Date: 25 February 2021  
Our ref: 14042/ 341688  
Your ref: M54 to M5 Link Road Project – TR010054

**NSIP: M54 to M6 Link Road - TR010054- Further written Questions and requests for information (ExQ3)**

**Table of NE Responses to Further Written Questions**

FIGURE 2.6
DRAFT ENVIRONMENTAL
MASTERPLAN
SHEET 4 OF 5

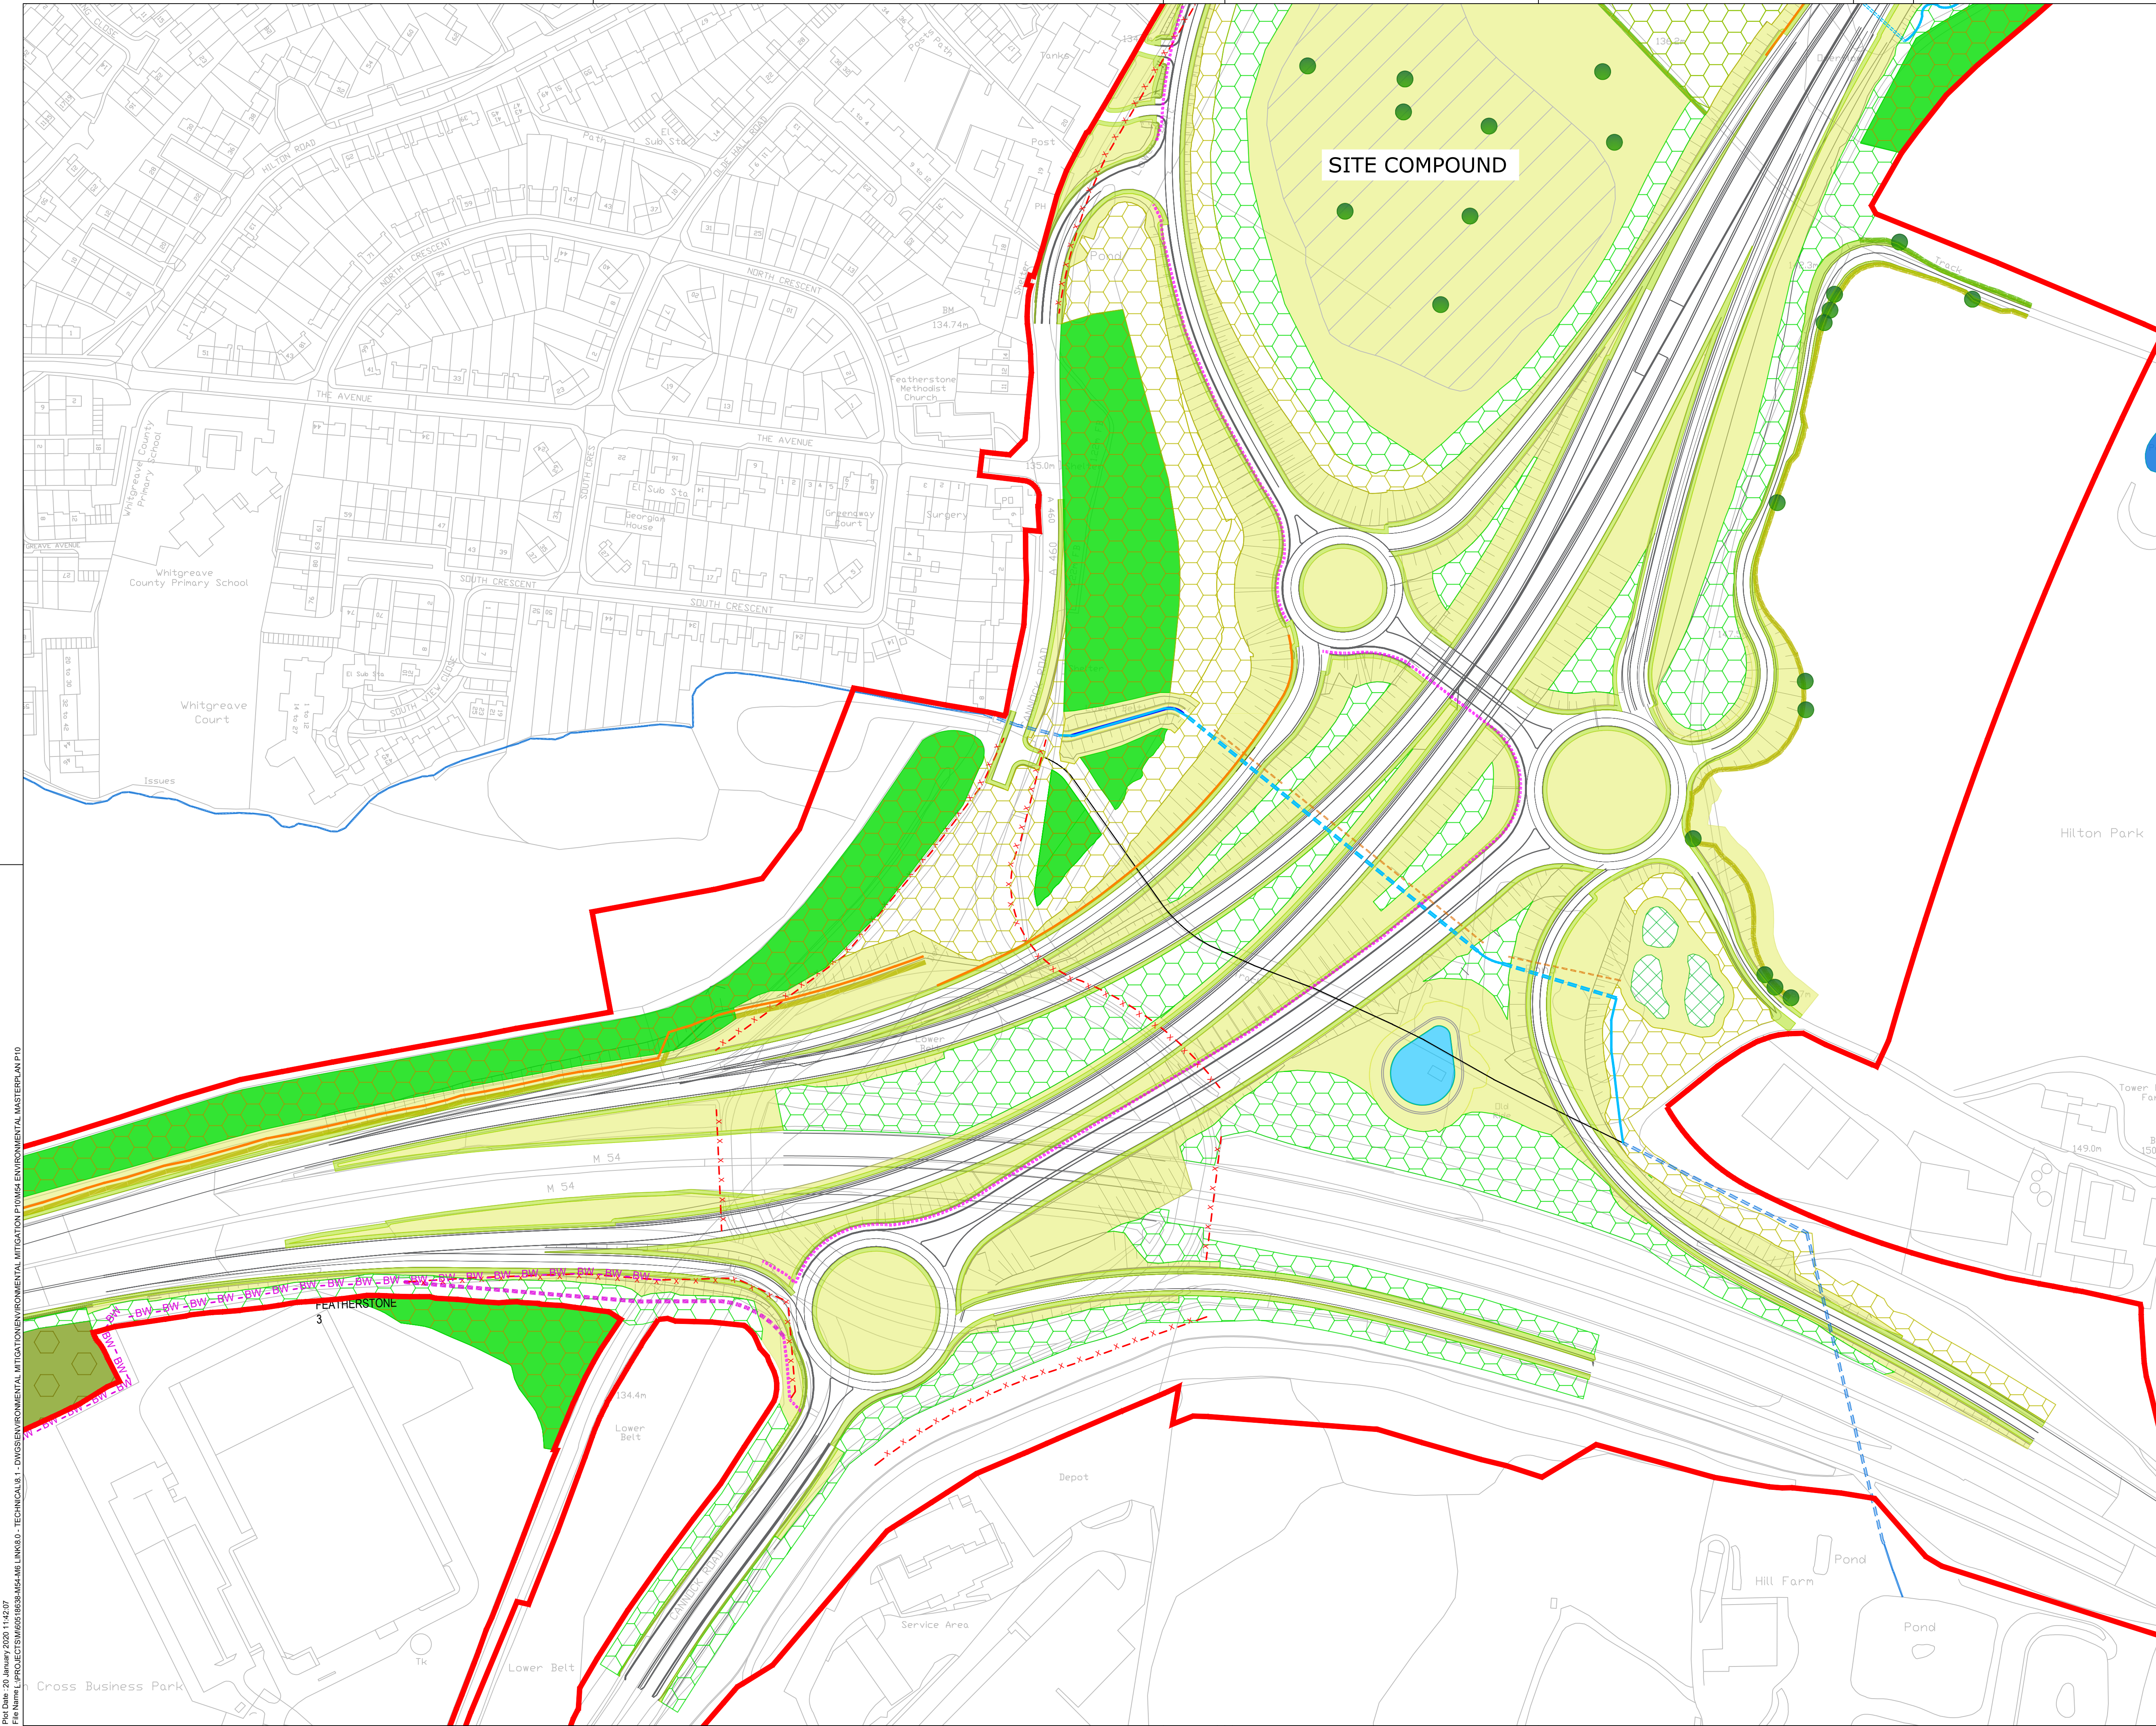
Question reference	Question	Natural England's Response
ExQ 3.3	<b>Biodiversity, Ecology and Natural Environment (including Habitats Regulations Assessment (HRA))</b>	
	<b>Veteran Trees</b>	
Q 3.3.7.	<p>Allow Limited proposal is that mitigation planting should be located to the east of the proposal.</p> <p>Could the parties set out their positions as to the effects of this planting, were it to occur, on the special interest of the two veteran trees in this field (trees T-178 and T-182) as shown on Environmental Statement Figure 2.5 (Ver P15) [AS-090]?</p>	<p>Veteran trees are important in their own right, and therefore are mentioned in the NPPF. Planting around veteran trees is not advisable as the veteran trees will quickly become shaded out. It is often also detrimental to interests that grow on them, especially lichens. We are not aware of what if any interests that grow on these two veteran trees.</p> <p>Veteran trees also support species of interest especially bats, nesting birds, and saproxylic species and this should be taken into account when considering planting.</p> <p>If planting is going ahead in this area, there should be a halo of at least 25m around the veteran trees that is not planted.</p>
